**WEST SUSSEX COUNTY COUNCIL
INFRASTRUCTURE CONSULTATION**

SUBJECT: LU/175/10

32-34 Fitzalan Road, Littlehampton

4 sign boards with flags and 1 hoarding with signage

**PROPOSED SIGNAGE
LOCATION & DETAILS**

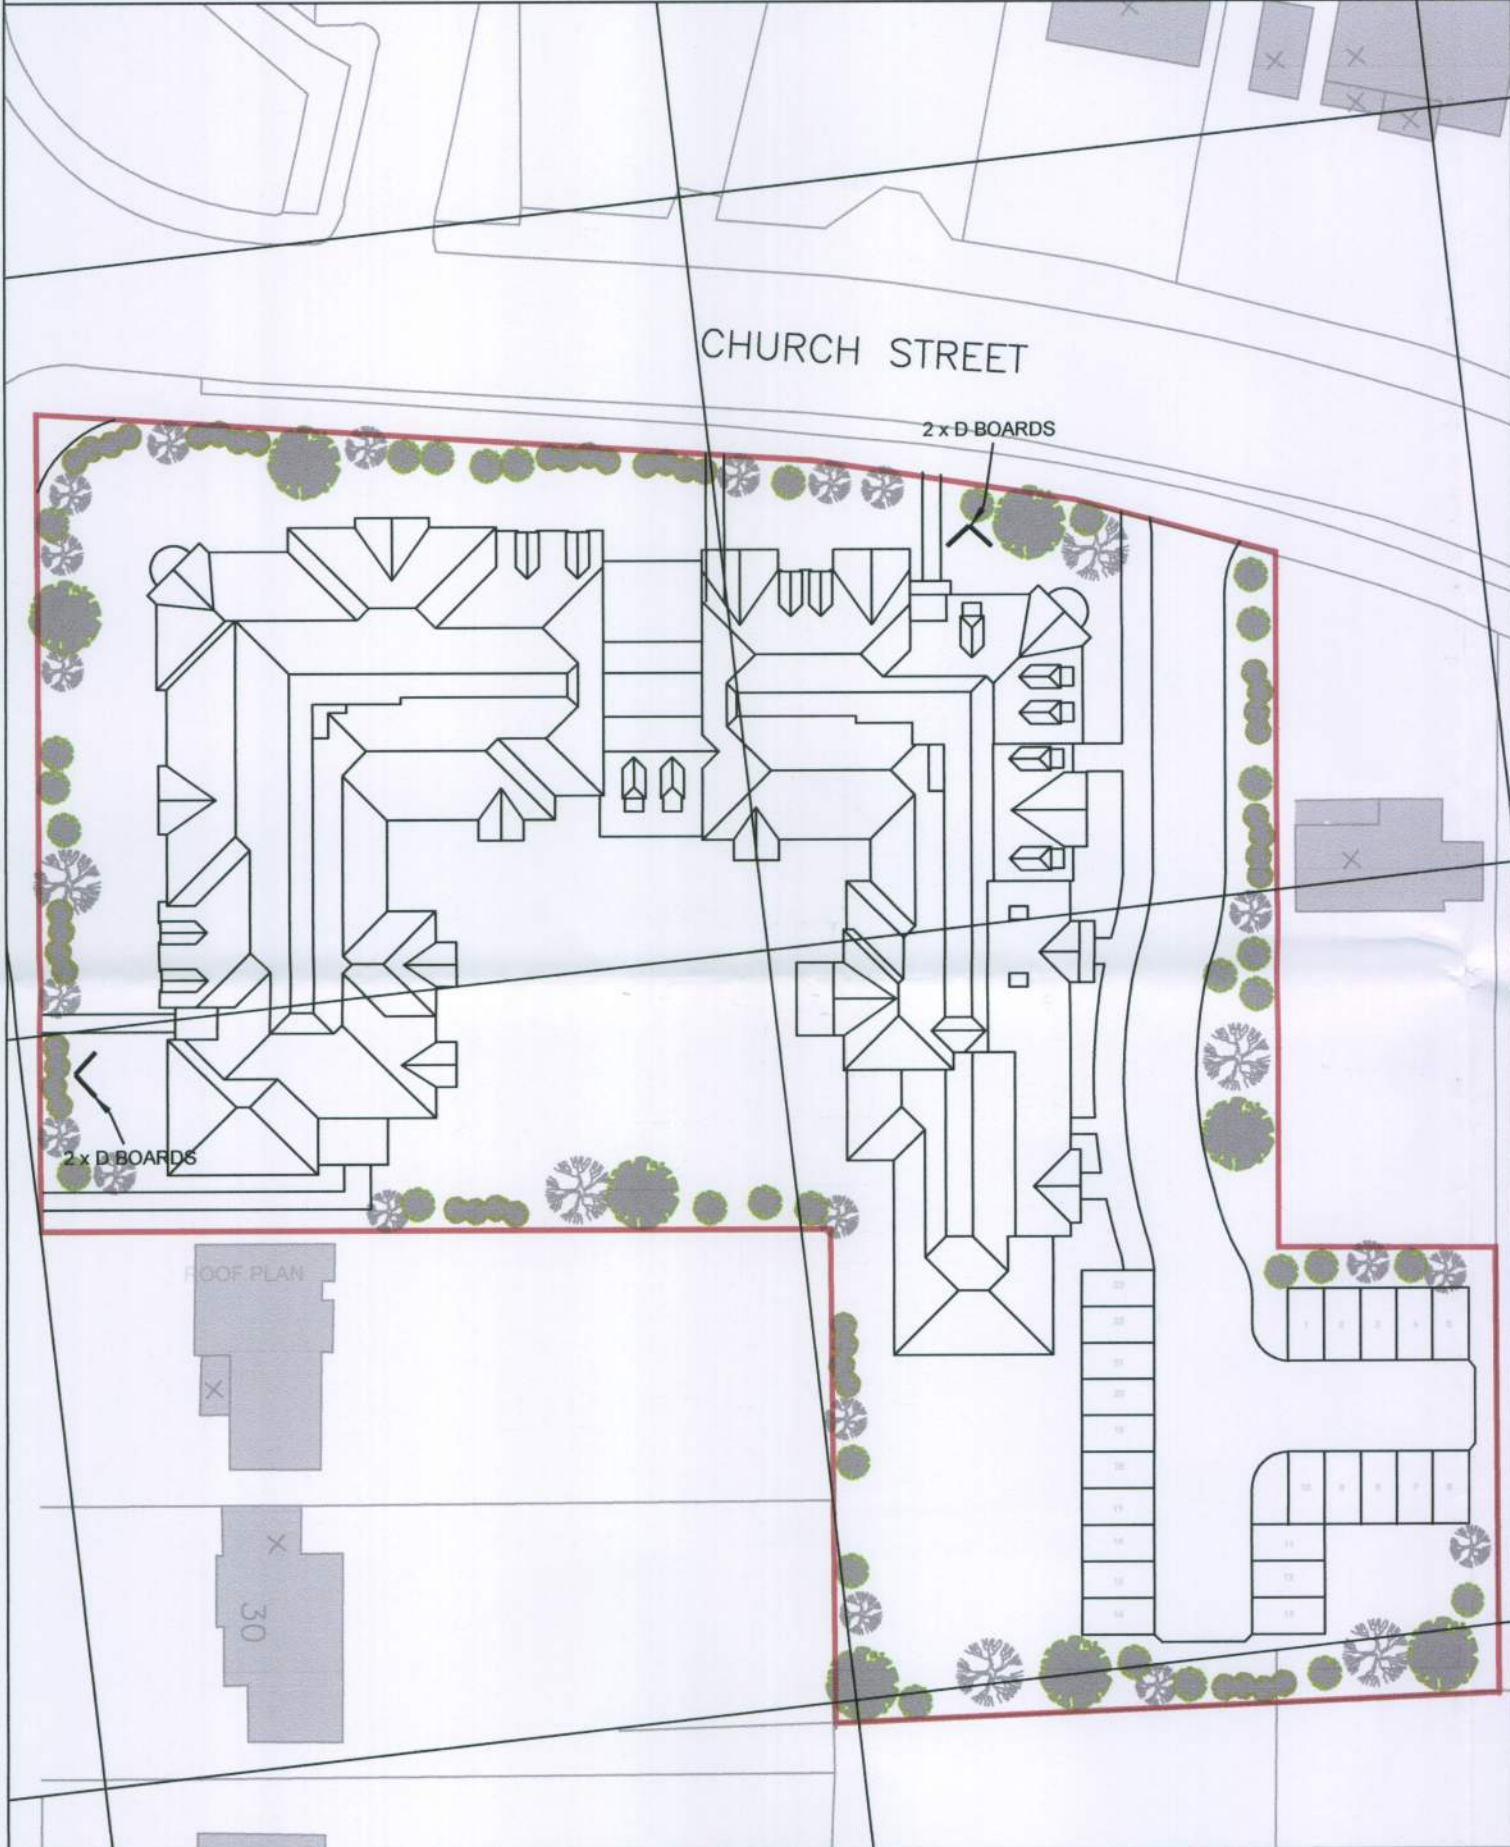
From an inspection of the plans it does not appear that any of the proposed advertising boards are to be located with the publicly maintainable highway. It also does not appear that the advertising hoarding will reduce pedestrian visibility at the access to Fitzalan House adjacent to the site.

No anticipated highway safety implications.
